# DELEGATED HOUSEHOLDER DECISION

**Address:** 21 PAMELA GARDENS EASTCOTE PINNER

**Development:** Erection of a wraparound dormer to rear and sides, installation of 1 front roof light and removal of chimney to create habitable roof space.

**LBH Ref Nos:** 6831/APP/2025/1858

GROUND FLOOR

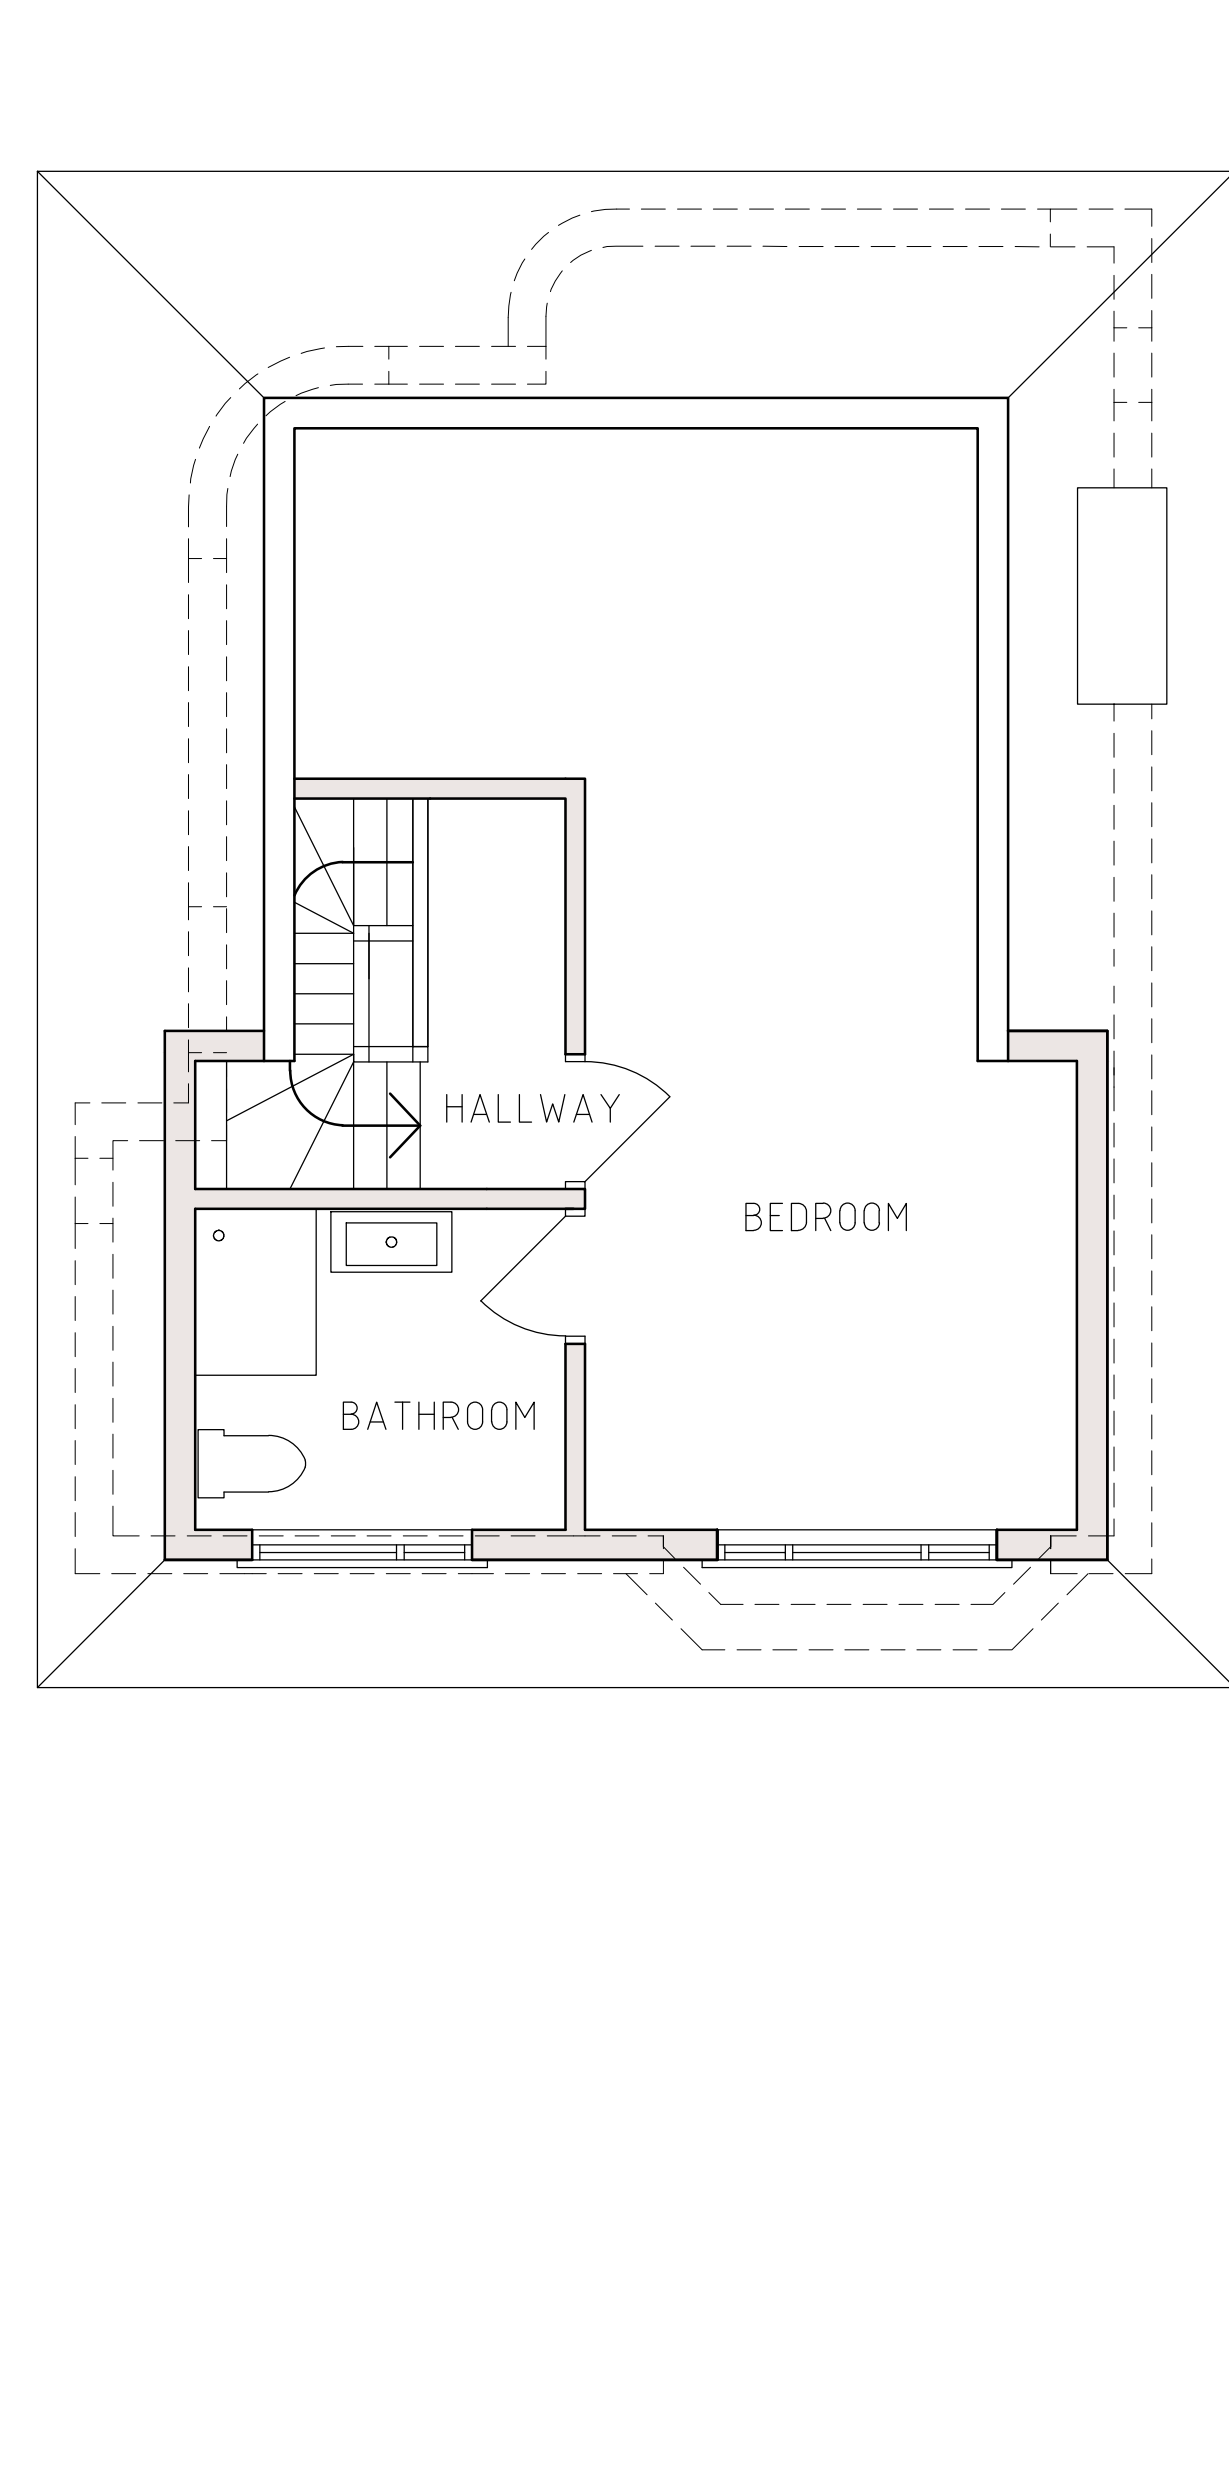
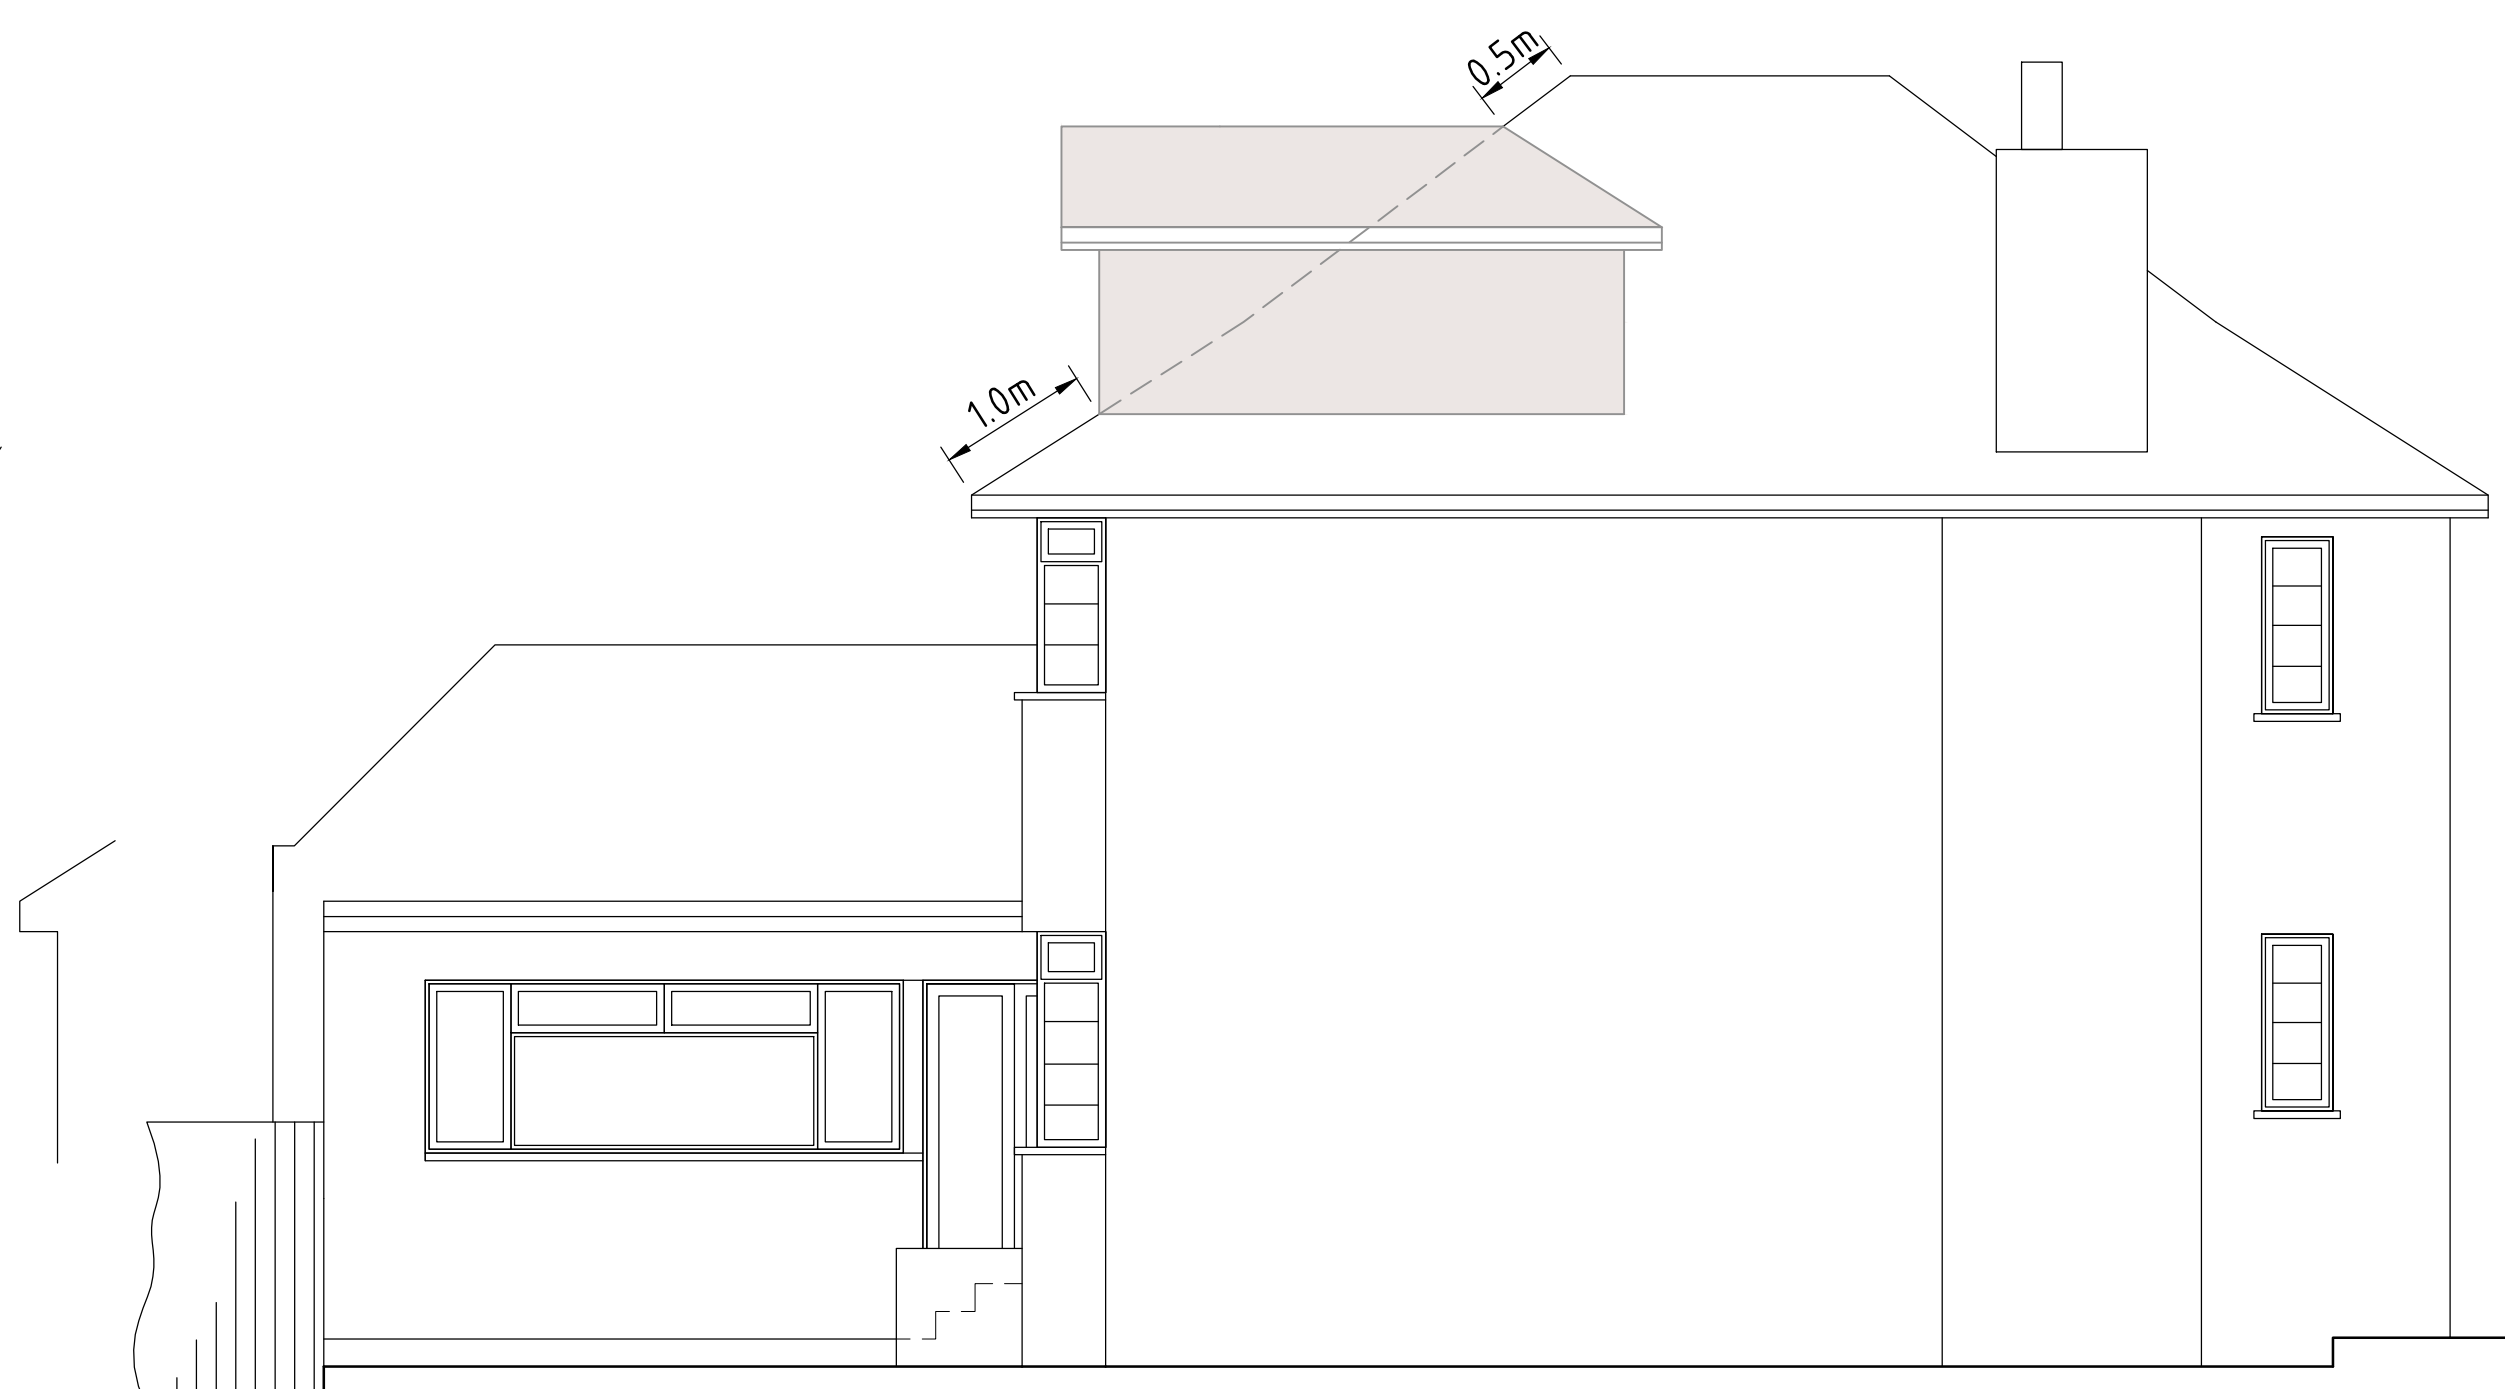
The proposed development seeks to construct a full-width wraparound dormer spanning the entire rear roof slope and projecting noticeably onto the side roof plane. The dormer occupies a substantial proportion of the original roofscape, adding considerable bulk and compromising the building's distinctive hipped roof profile.

A wrap around dormer with the width of 6m and height of 1.9m and a depth of 2.9m is proposed which would result in an overspill and the formation of side dormers. The proposal involves extensive alterations to the roof profile which involve an increase to its width and make it appear discordant and at odds. The Local Plan states that dormers should not be overly large, and 'box-like' dormers to the side of the property or in protected areas will be unacceptable. As a general rule, dormers should not be more than two-thirds the width of the roof face of the property. They should be centrally positioned, set down below the ridge of the roof, and set up from the eaves.

Whilst they would be set in above the eaves by 1m and down from the ridge by 0.5m, they would fail to appear subordinate to the main house and would be of a significant bulk and massing, covering more than two-thirds of the width of the roof face on each side. These would be located close to the property's frontage and prominent on the street and appear at odds, especially given

In design terms, the dormer fails to draw from, or respond to, the architectural language of the host dwelling. The fenestration is of a standard domestic appearance with no reference to the building's characteristic horizontal emphasis or curved detailing. Its scale and positioning result in an unbalanced roof profile that disrupts the carefully proportioned elevations.

The design, width, bulk, and massing of the dormers mean that they would significantly alter the roof form when viewed from the street, and overall, it is considered that they would cause unacceptable harm to the character and appearance of the area. The property is an art deco and in a conservation area whereby it is paramount that properties are designed of a good quality and standard and preserved. Given this, the visual harm caused by the wrap around dormer on the property and the scale and massing of the side dormers cannot be accepted.

The dormer overspill to the sides causes overbearing issues as the gap is a paramount feature of the properties in the area. The visual harm is considered sufficient to justify a refusal of planning permission.

The proposed wraparound dormer, by reason of its excessive size, scale, bulk, height, and design would fail to harmonise with the architectural composition of the original dwelling and would be detrimental to the character, appearance, and visual amenities of the street scene and the surrounding area. The proposed development, by reason of the wrap around dormer and overspill to the side, its proximity to the neighbouring properties and the reduction of the prevailing gap space, would result in a form of development that would cause less than substantial harm to the conservation area without any notable public benefit. Therefore, the proposal would be contrary to Policy D3 of The London Plan (2021), Policy BE1 of the Hillingdon Local Plan: Part One - Strategic Policies and Policies DMHB 4, DMHB11, DMHB12 and DMHD1 of the Hillingdon Local Plan - Part
